# HERTFORDSHIRE GARDENS TRUST

26 March 2021

**Re: Former Shredded Wheat factory, Broadwater Road, Welwyn Garden City AL7 1RR**  
**Hybrid planning application comprising: Detailed Planning Application for 399 Private Rented Sector (PRS) dwellings and 153 dwellings (Class C3), 250 units of residential car accommodation for the elderly (Use Class C2) with associated communal facilities, 15,247m<sup>2</sup> of community and commercial hub (Use Classes E and F1) with associated cycling hub, car parking, access, landscaping, public art and other supporting infrastructure; and Outline Planning Application for up to 418 dwellings (Class C3) with all matters reserved except access.**

10.3. SCALE AND MASSING

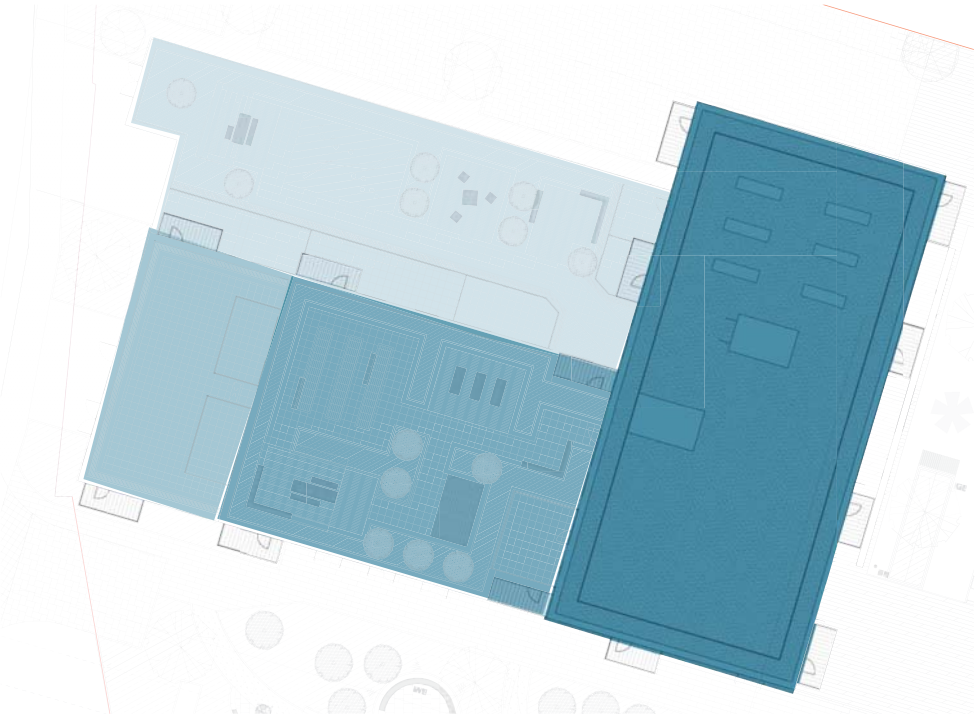
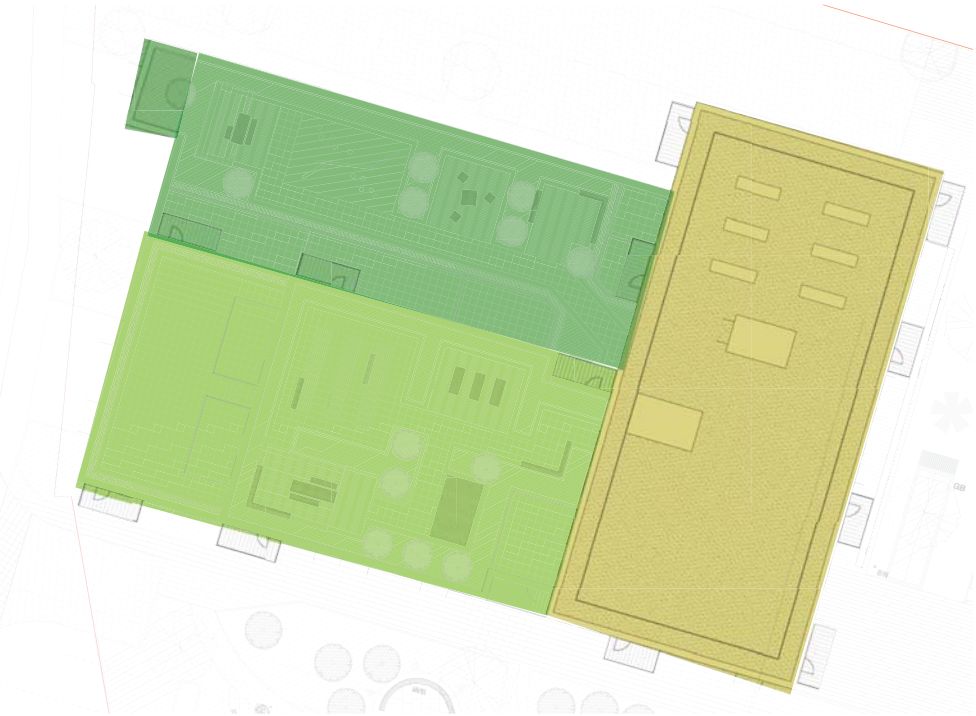
5. Many of the traditional houses in the town will be adversely affected, not only by the looming bulk of these blocks, as demonstrated in the application at Appendix 10.3, but also by increased traffic densities.
